AW/6/09/

PLANNING APPLICATION REPORT**REF NO:** AW/6/09/**LOCATION:** 4 Arun Way
Aldwick**PROPOSAL:** Proposed garage.**SITE AND SURROUNDINGS**

PROPOSED FRONT ELEVATION STREET SCENE - NORTH WEST

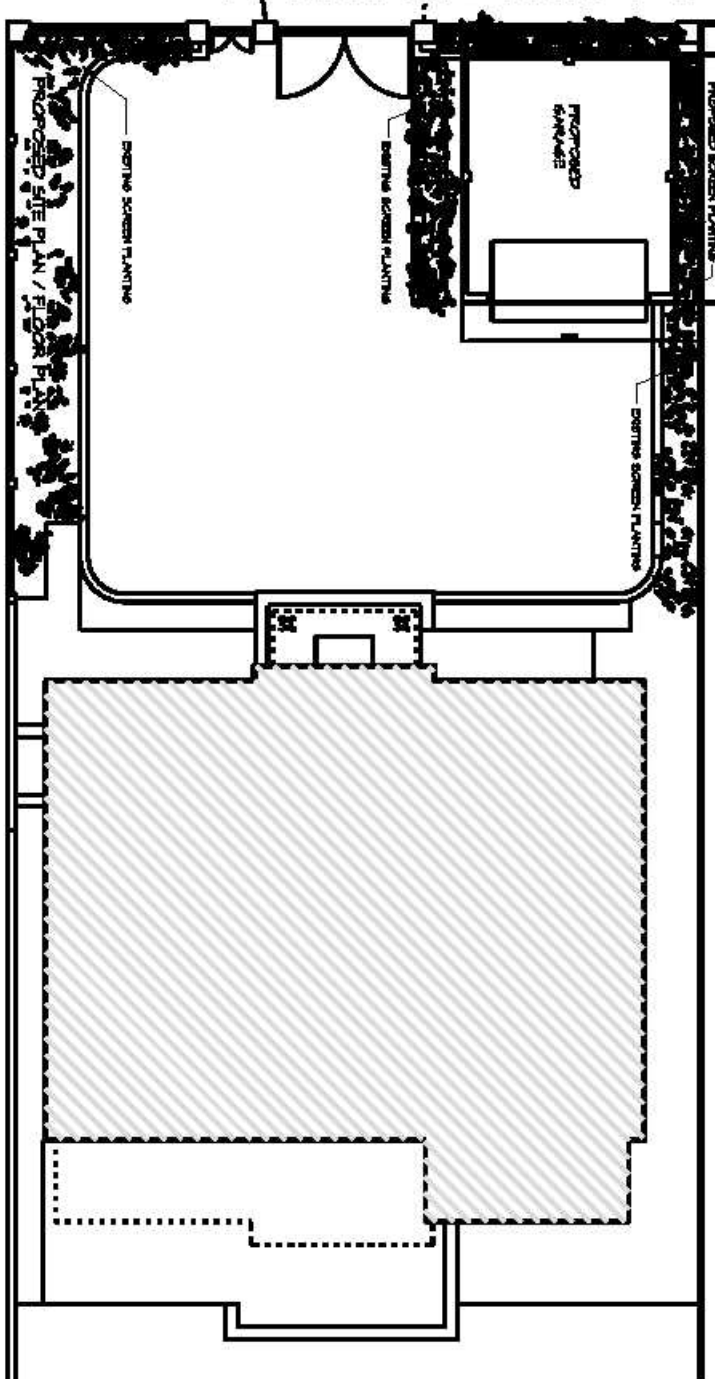
The proposal is for a garage on the front boundary 6.5m by 5.5m (4.3m high). Several applications for garages on this site forward of the dwelling have been refused. The previous application AW/88/06 was dismissed at appeal. The Inspectors reason was concern regarding the harsh visual appearance within the street scene, due to lack of existing screening. Also there was concern that the view on entering Arun Way would be of garage doors.

Whilst some effort has been made by the applicant to overcome the previous reason for refusal by planting screening to a height of approximately 3.5m and moving the garage doors to the rear, facing the house, it is considered that the main concern that the garage would be sited in a visually prominent location to the front of the property where it would diminish the open appearance of this part of the estate still applies.

It is considered that the existing and additional proposed planting and the resiting of the garage doors to face the front of the property, rather than the road, are not sufficient to overcome the previous reason for refusal and that the proposed development would result in material demonstrable harm contrary to the provisions of the Development Plan. There are no other material considerations of sufficient weight to justify a decision other than in accordance with the Development Plan, therefore it is recommended that the application be refused for the following reason:

BLOCK PLAN 1500

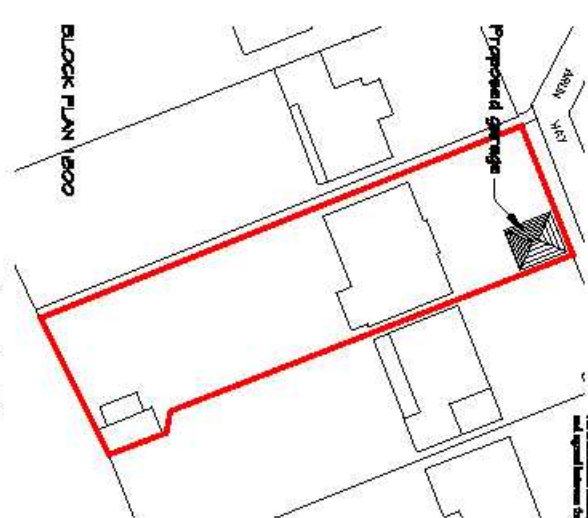
Whilst it is accepted that there are outbuildings at the end of the cul-de-sac (No.1) and to the front of No.5, these existing buildings are not unduly visually prominent and are not readily viewed upon entering the cul-de-sac. The proposed garage building, conversely, because of its siting and form would be extremely prominent and would detract from the appearance and open character of Arun Way to an extent that would be contrary to the provisions of policy DEV1 and GEN7.

- 1 The proposed garage to the front of the property would, as the result of its siting and size, be visually prominent within the street scene and would erode the open aspect of this part of the estate. The proposal would thereby be detrimental to the visual amenities and character of the locality contrary to the provisions of policies DEV1, CH1 and LOC1 of the West Sussex Structure Plan and Policy GEN7 of the Arun District Local Plan.
